## **DR NORMAN JORGENSEN**

### **WRITTEN REPRESENTATION**

#### **HIGHWAYS ENGLAND'S RESPONSE**

Project	SMART MOTORWAYS PROGRAMME
	M4 JUNCTIONS 3-12
Drawing title	ENVIRONMENTAL MASTERPLAN
	REGULATION 4(2)(e)
	SHEET 14 OF 61
	LOWER EARLEY

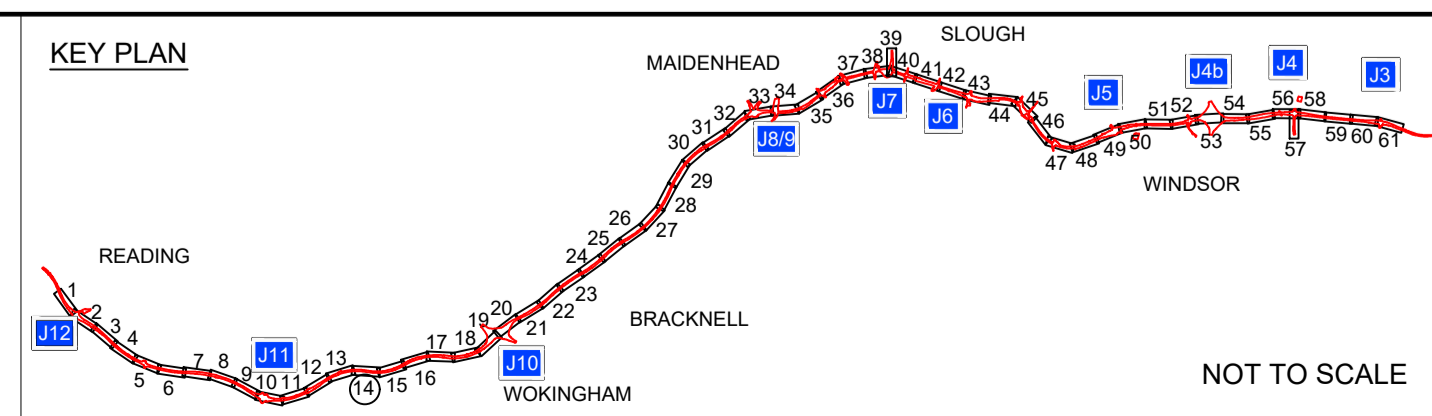
2. *As a result of the Enhanced Noise Mitigation Study it is now proposed to erect a 2.5m high absorptive acoustic barrier of approximately 2km in length where the M4 passes Lower Earley. I welcome this and it will help the many residents of Earley who endure noise from the M4.*

3. *However, it appears that those areas which currently have protection from 2m or 2.5m high barriers are to have those upgraded to 3.5m high. Why not 3.5m high barriers for Lower Earley?*

4. *As the M4 goes past Lower Earley some properties are very close to the Motorway while others are further away. Please will you further consider the level of protection for those properties closest to the M4 in Lower Earley and specifically those located in Worrall Way, Tickhill Close, Notton Way, Finbeck Way and Maltby Way. These properties sit above the Motorway and as I demonstrated during the accompanied site visit to Notton Way on 9 February many properties currently have direct line of sight to the wheels of vehicles going by on the Motorway.*

5. *I submit that these properties at least should be provided with the same level of protection as those in Winnersh which are to be provided with 3.5m high barriers. This would require approximately 400m of the 2km long Lower Earley barrier to be 3.5m high rather than 2.5m.*

- 5.2 The Lower Earley area was considered as part of the enhanced noise mitigation study (reference EM8), issued at Deadline VII, and was treated in exactly the same manner as all other areas in the study. The outcome of the assessment was that a new 2.5 metre high barrier should be provided. The length of the new barrier will be 2,126 metres. The barrier will be of the absorptive type.

- 5.3 The outcome of the assessments for other locations in the study area (such as Sindlesham and Winnersh) may be different to Lower Earley, as each outcome is based on the result of the three part process described within the enhanced noise mitigation study, which takes into account the estimated noise reductions, the number of properties benefitting and the associated health benefits, and the costs of the barrier or barriers. Consequently, because a 3.5m barrier is appropriate in one location, such as Sindlesham, this does not mean that such a barrier would necessarily be appropriate in other locations.

- 5.4 With respect to the specific streets mentioned by Dr Jorgensen (Worrall Way, Tickhill Close, Notton Way, Finbeck Way and Maltby Way), as noted in the response by Highways England to Mr Jorgensen's representation at Deadline VII the computer model, employed to calculate road traffic noise levels for the Scheme, includes a detailed "digital ground model". This ensures that the M4 motorway, all other roads in the study area and all buildings (including residential buildings in these specific streets) are placed at the correct height above sea level. These differences in ground height are taken into account in the calculation of noise levels and the noise reductions provided by barriers.

- 5.5 The changes in noise levels across Lower Earley, with the enhanced noise mitigation in place are shown in Sheet 4 of Drawing 3 in the Enhanced Noise Mitigation Study Report issued at Deadline VII. The specific streets mentioned by Dr Jorgensen are predicted to experience noise reductions of 3 to 5 dB with the Scheme in operation.
